Intake Screening Packet Response Memo

4/1/21

Project Name:	Yaroslavsky Residence
Address:	3535 S Ferdinand St
Permit Number	2103 092

This memo is prepared to respond to all items raised in the intake screening packet dated 3.16.2021 as follows:

SITE STORM & UTILITY PLAN

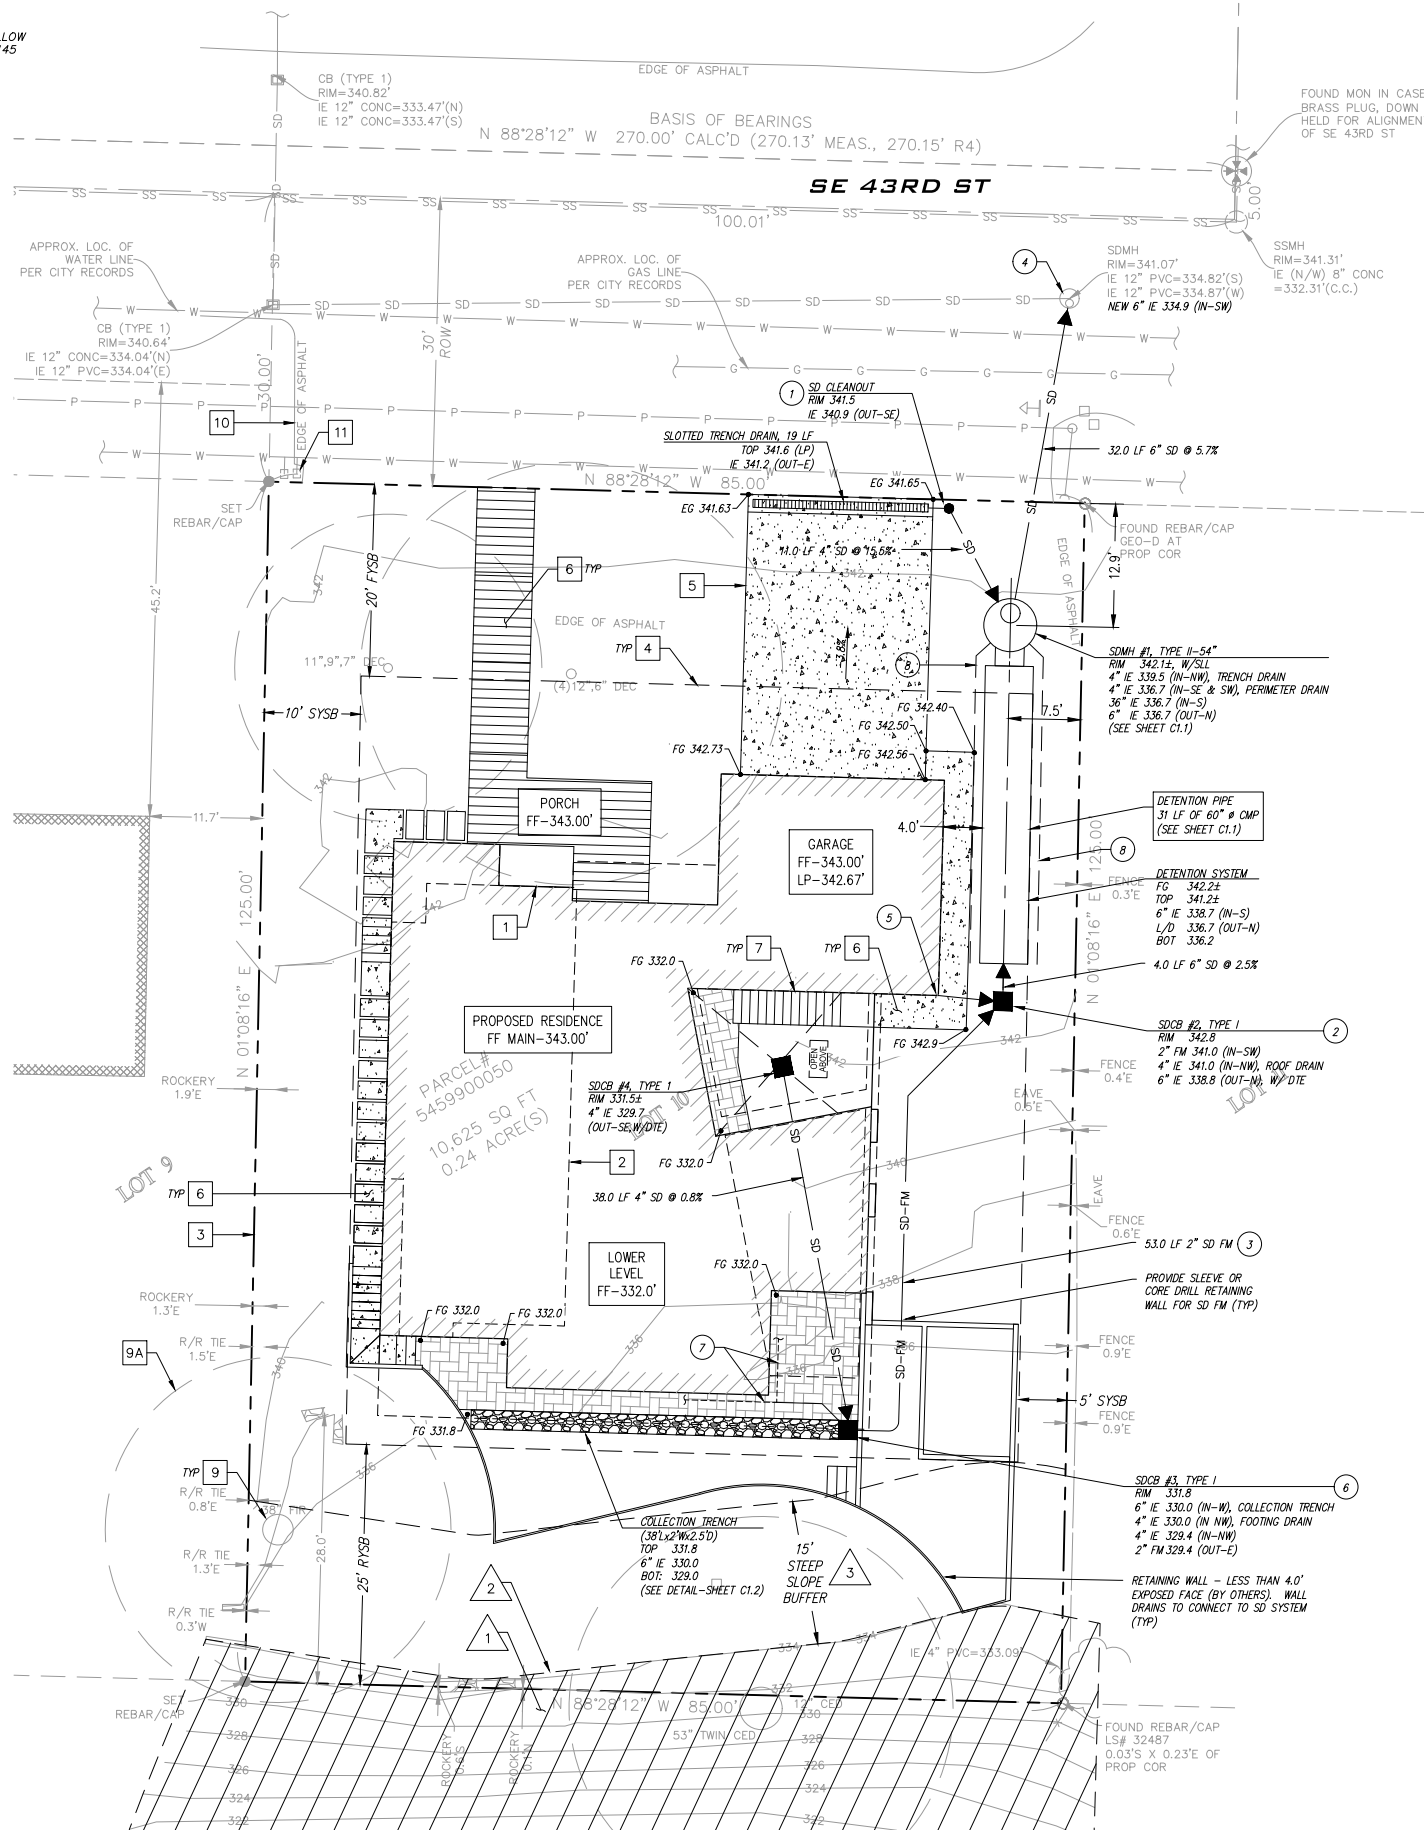
Arborist report to be given to Civil for design. Detention and utilities to be placed as to not damage exceptional trees. If tree 631 is non exceptional and may be removed if that is the only place for detention. If the minimum percentage of total trees is retained. See link for checklist for Civil/Tree plan https://www.mercerisland.gov/sites/default/files/fileattachments/community_planning_amp_development/page/21988/treessubmittalchecklist.pdf

Revised Drawings and Arborist Report have been provided to civil engineer and civil set has been updated accordingly. Revised drawings are included as part of this submission.
